Guildford Borough Councils response to ExA's Third Written Questions (Ref: ExQ3)

GBC ref: 19/CON/00026/ExA.Q3

Figure 1: Replacement Land locations and existing special category land

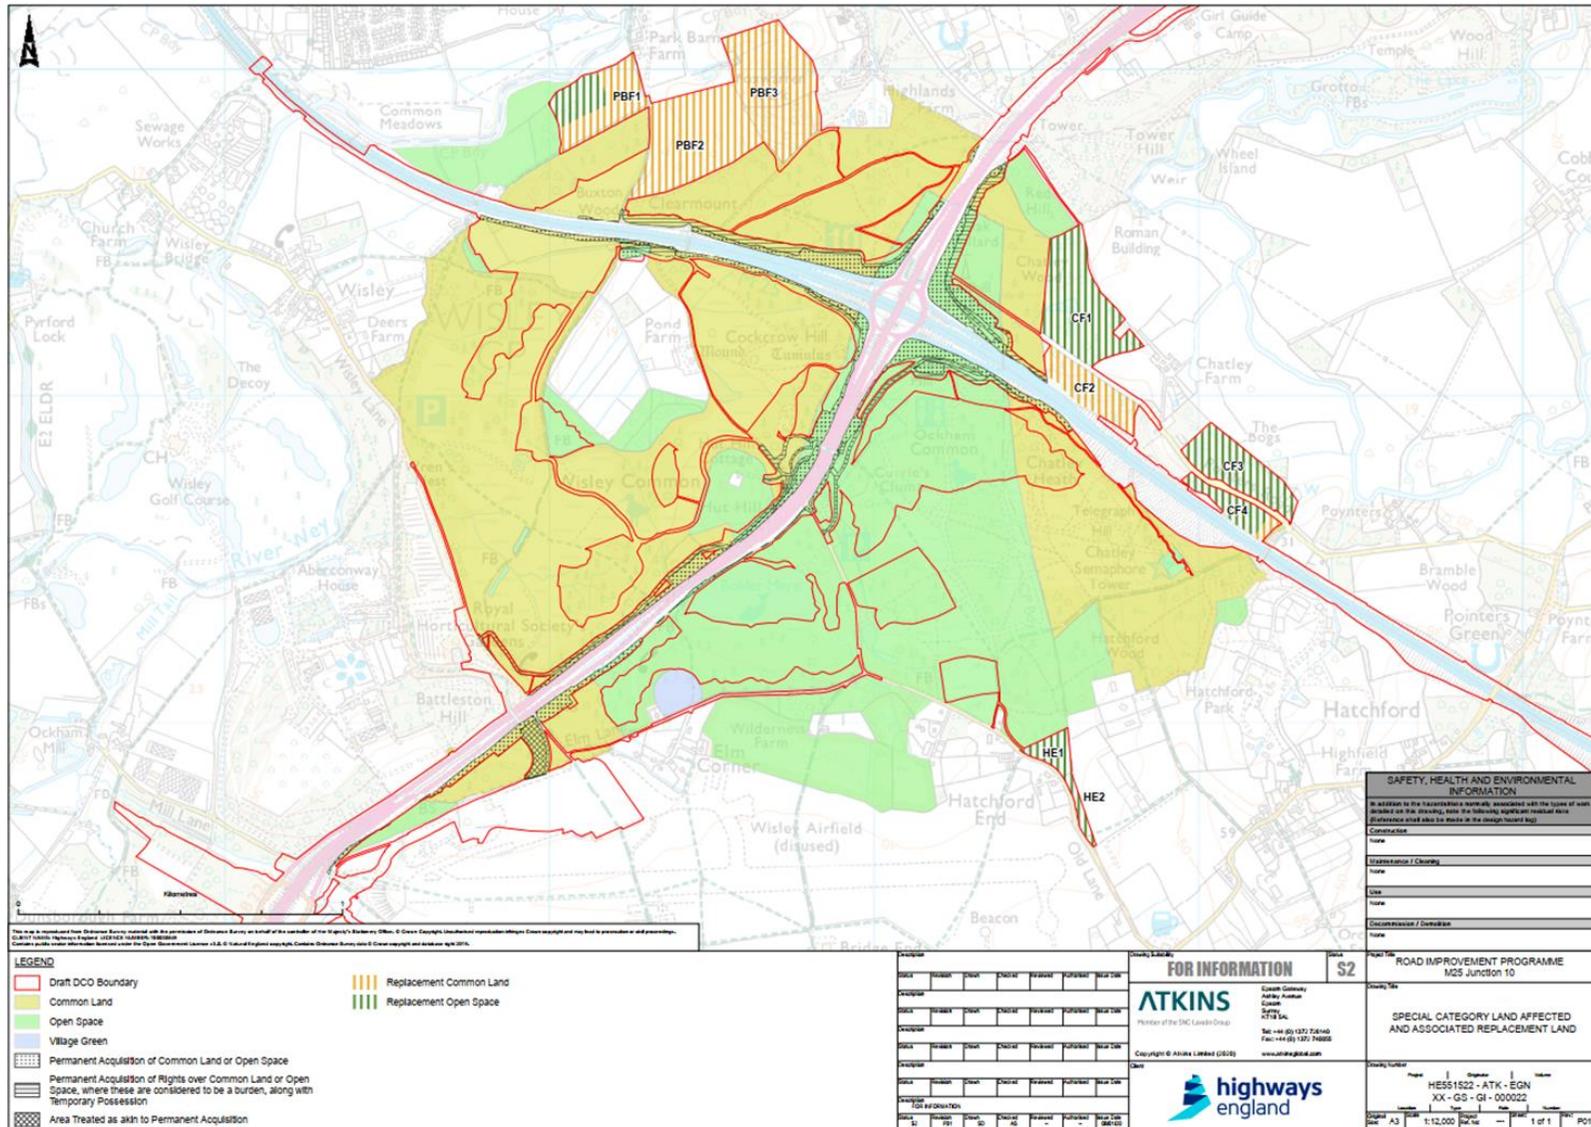
3.9.3	SCC, EBC and GBC	<p>With respect to the proposed provision of replacement land in exchange for SCL and the range of possible options outlined in Table 1 of the 'Note on Implications of Potential Reduction in Replacement Land' [REP5a-012], please:</p> <p>a) identify the three SCL options in Table 1 that you most and least favour, ranked in order of most/least preferred; and</p> <p>b) explain the reasons for those choices.</p> <p>Without prejudice to any representations you have made at earlier deadlines for this Examination concerning the provision of SCL replacement land, in answering this question each local authority is requested to disregard any 'in-principle' type objections they might have to a reduction in the target ratios stated by the Applicant in AS-005. Additionally, in answering this question each local authority is requested to take account of the following factors:</p> <p>i. the underlying purposes for having the Common Land and Open Space;</p>	<p>Notwithstanding that GBC considers that the ratios are not excessive, having regard to Table 1 the most to least preferable options are as follows:</p> <p>Most preferable (most preferable first):</p> <p>Option 5: this not contiguous with other existing or proposed SCL</p> <p>Option 7: this is a relatively small area but has the benefit of being contiguous with the wider area of Ockham Common</p> <p>Option 6: this not contiguous with other existing or proposed SCL</p> <p><u>Least preferable (least preferable first):</u></p> <p>Option 3: largest reduction in area and an area which has good links to existing SCL</p> <p>Option 2: large area of high-quality value area with good connectivity and</p>

<p>any user benefits and/or disbenefits in terms of the proximity of any replacement SCL to what would be the retained SCL;</p> <p>iii. the patterns of use for the existing SCL; and</p> <p>ii. the future patterns of use for the existing and new SCL.</p>	<p>would result in loss of new bridleway link</p> <p>Option 8, 9, 10: large area and accumulation of effects</p>

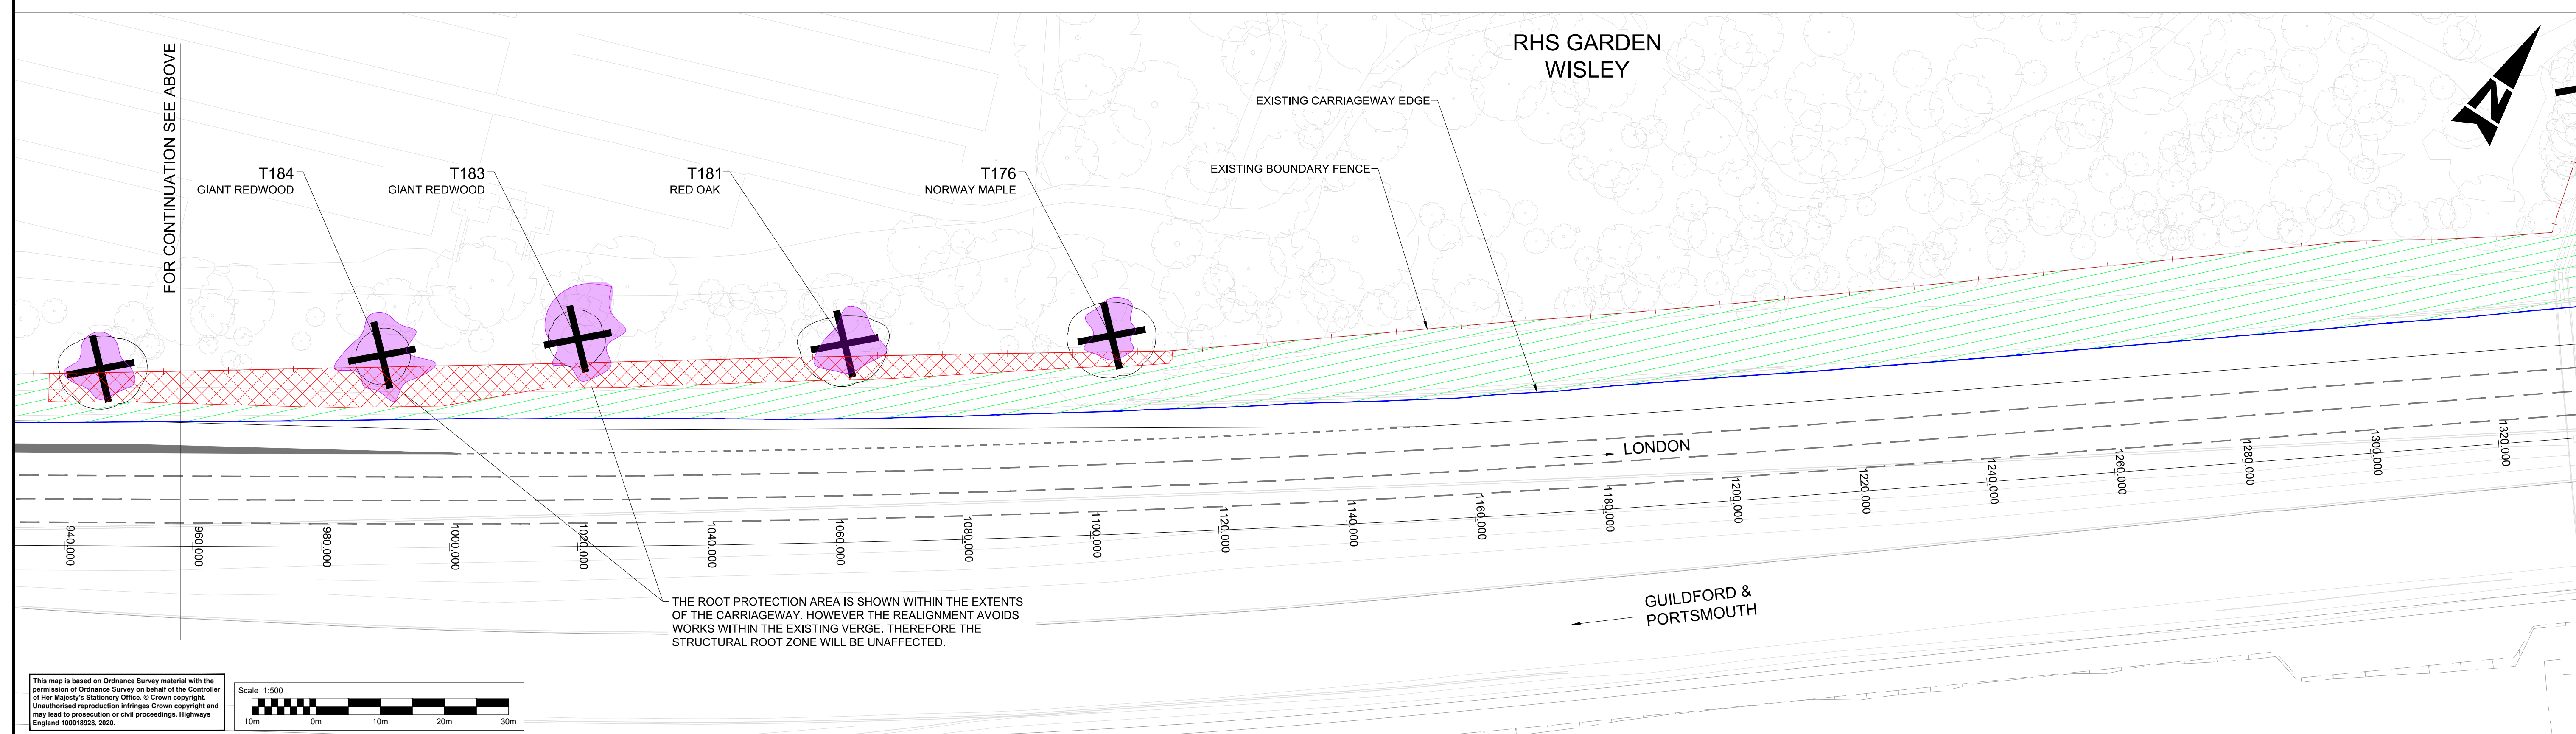
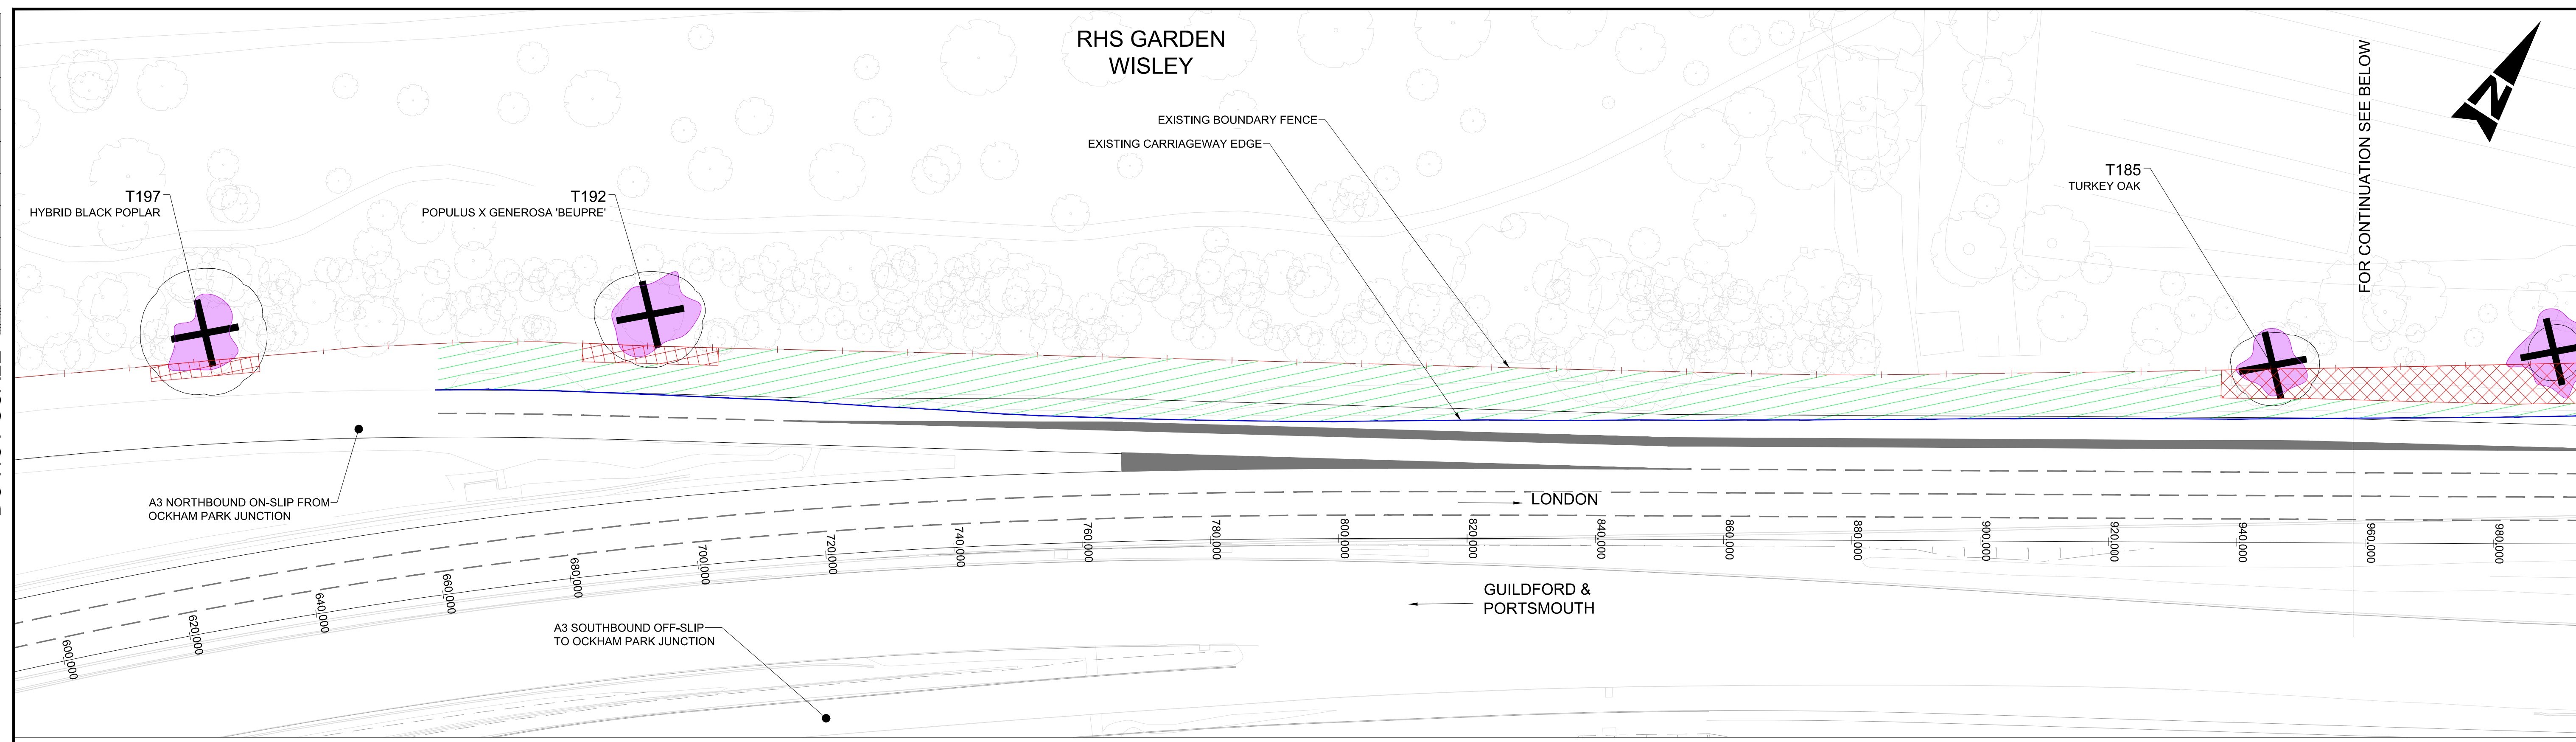
3.15.17	GBC and RHS	Please set out any concerns or comment you may have on the new Requirement 18 (Protection of certain tree roots at RHS Garden Wisley) in the dDCO [REP5- 002].	<p>The RHS Tree Protection Plan shows the red hatched areas to be an area where “no plant, materials or vehicles” will be used or stored. If this is the objective of the Requirement then this should be secured by the requirement.</p> <p>GBC is not convinced that “except with the consent of the owner” is appropriate and would result in an agreement process that was divorced from other agreement which is generally by the SoS, in consultation with LPAs and/or IPs.</p> <p>GBC would suggest that the requirement should be amended, to be more precise and enforceable. It should either preclude works in these areas or should require the submission of a</p>

method statement for any works in these areas for the approval of the approval of the SoS following consultation with LPAs and IPs
--	--	--	--
